Subject: FW: 3/2014/0996

From: Carter, Philip A [<mailto:PCARTER@environment-agency.gov.uk>]
Sent: 11 February 2015 15:46
To: Judith Douglas
Cc: John Macholc
Subject: RE: 3/2014/0996

Drawing Title
PROPOSED GROUND FLOOR PLAN

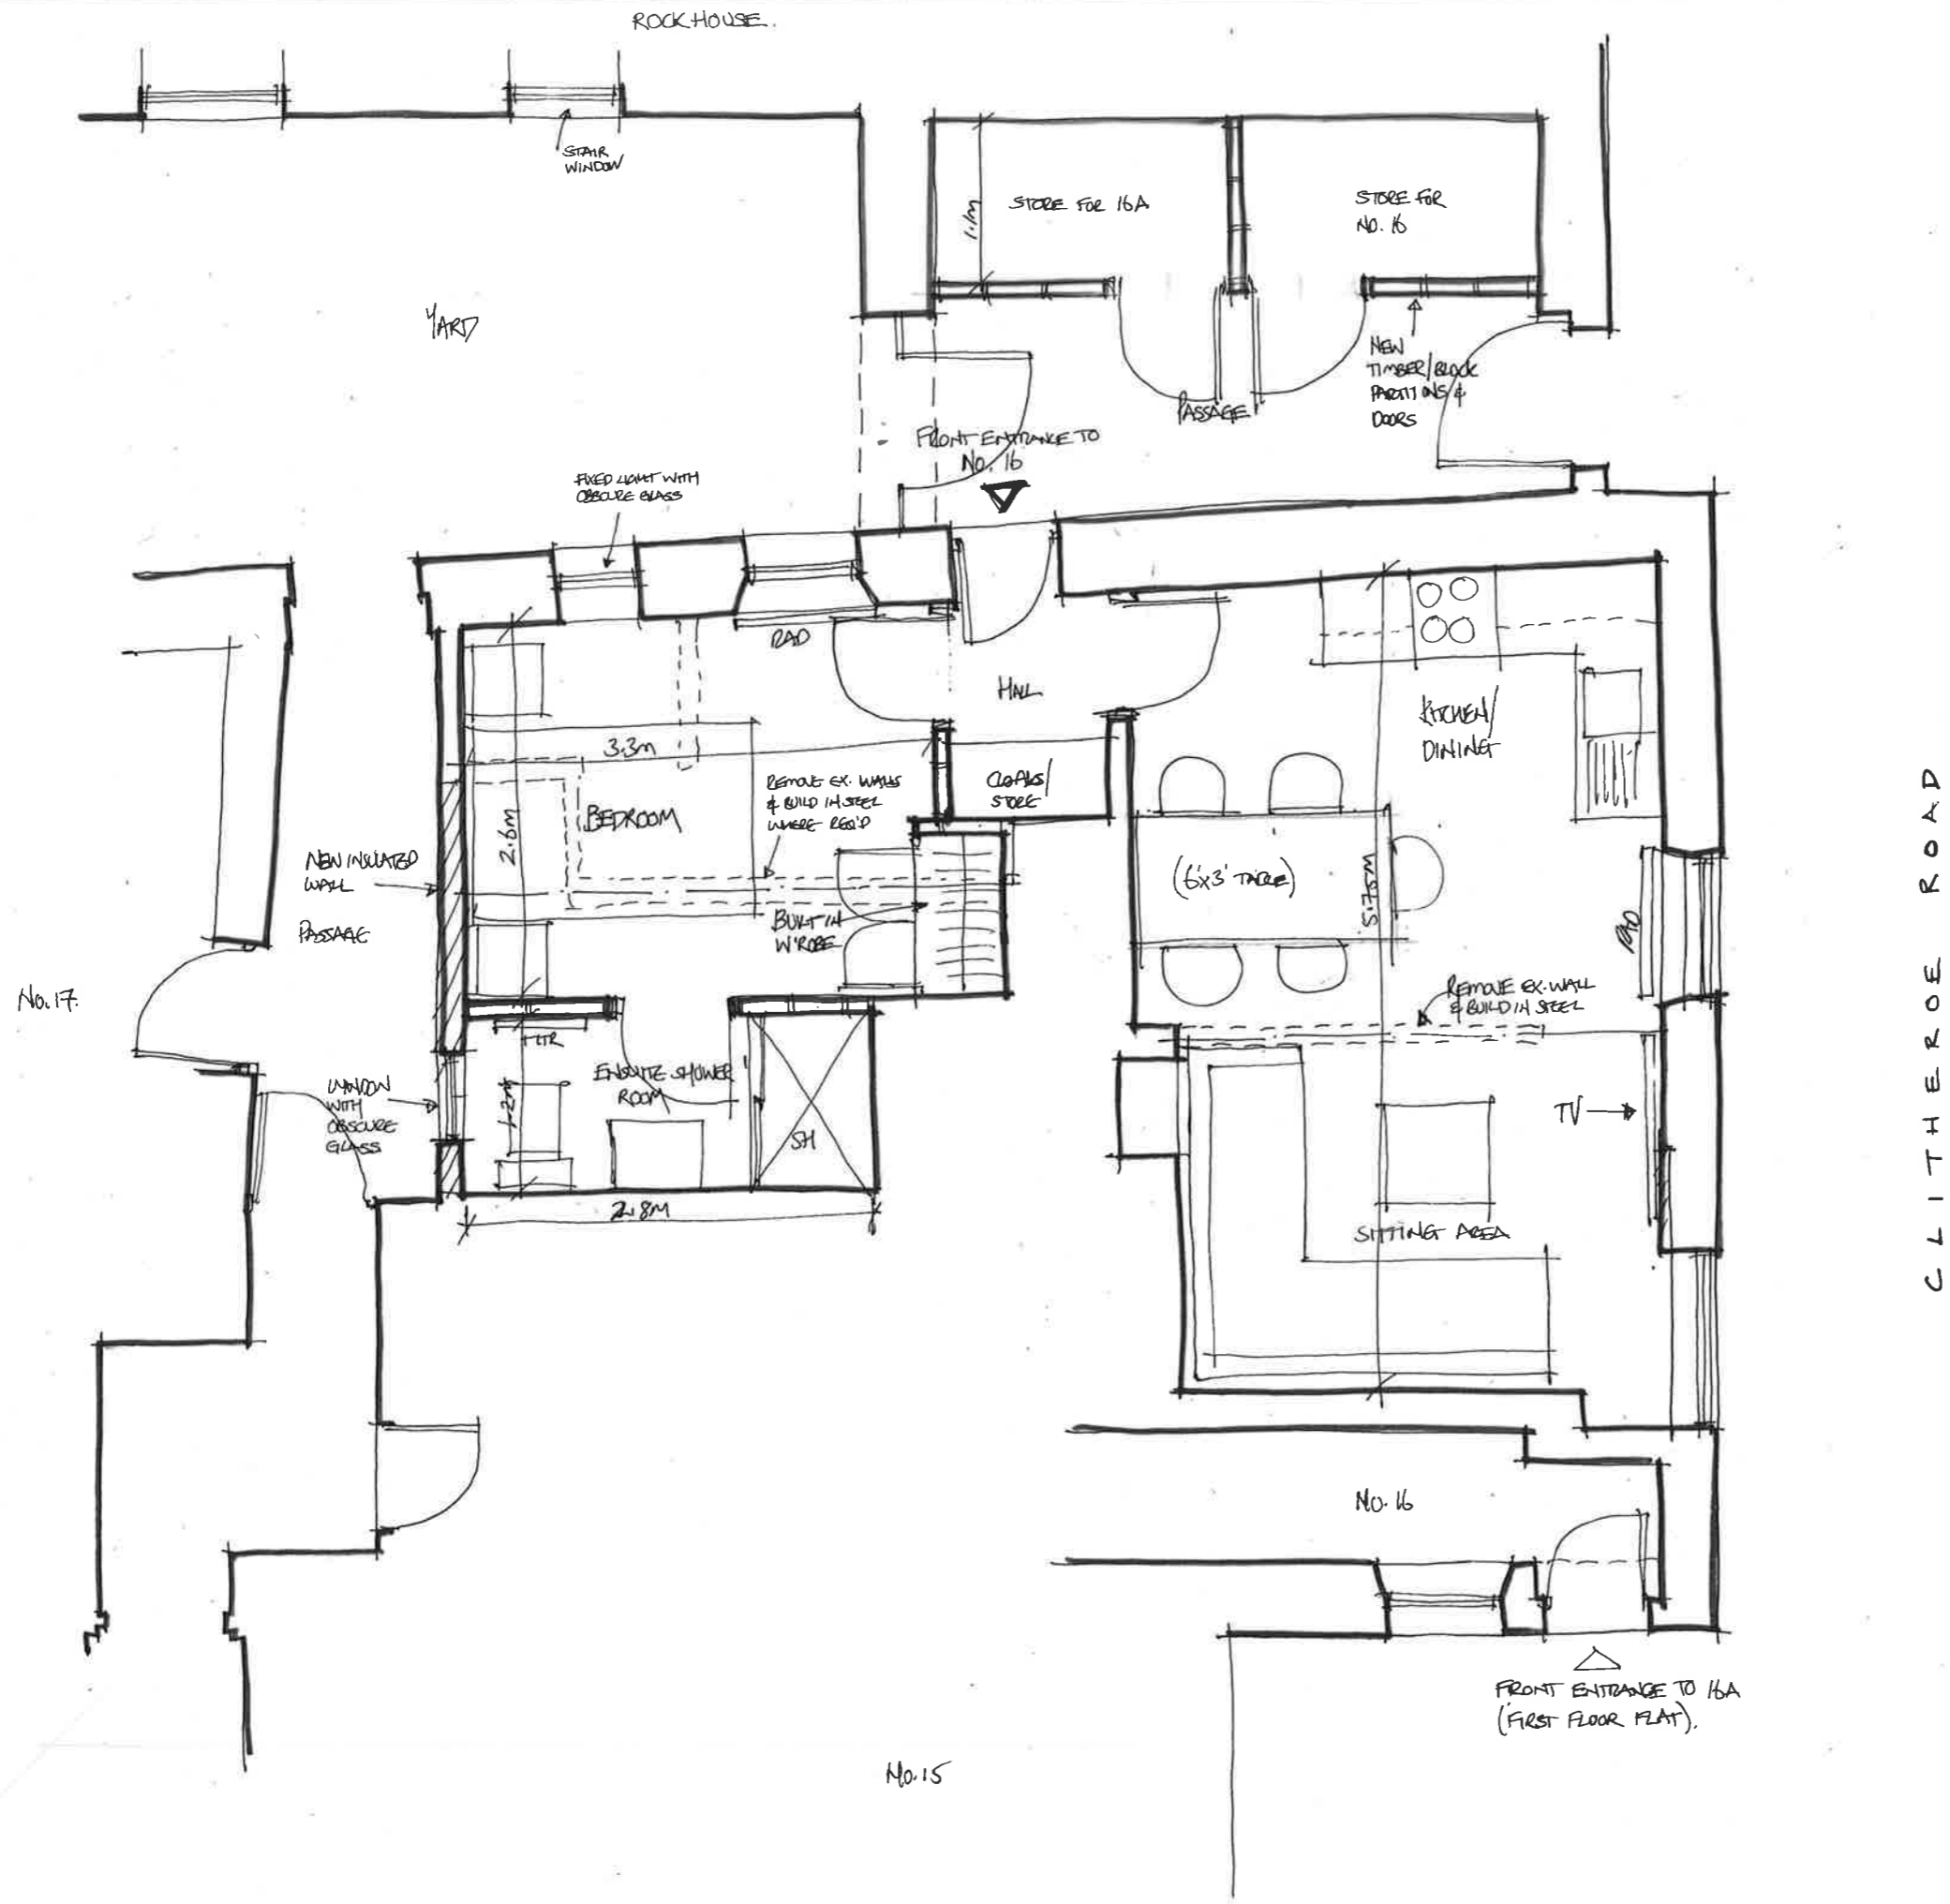
Judith, further to my previous e-mail, I've just spoken with James Jackson who reviewed the FRA. He has advised me that he spoke to the flood risk consultant to discuss what to do to overcome our objection and suggested that a proposal to install a permanent step at the access to the property to prevent the ingress of water would be sufficient to overcome our objection. The revised FRA makes no reference to such a permanent feature.

We can assume a potential flood depth of around 400mm based on the topographic survey included in the FRA when comparing it to our more detailed flood map. If the FRA is amended to include reference to a new, permanent step(s) at the front access off Clitheroe Road measuring at least 400mm in height, this will be sufficient to overcome the objection as it will reduce the risk of water flowing into the building. This is in addition to the temporary flood boards that are already included in the FRA (which will provide an element of freeboard allowance). If a revised FRA is submitted to this effect and received by the end of today or first thing in the morning, we can look to withdraw the objection then.
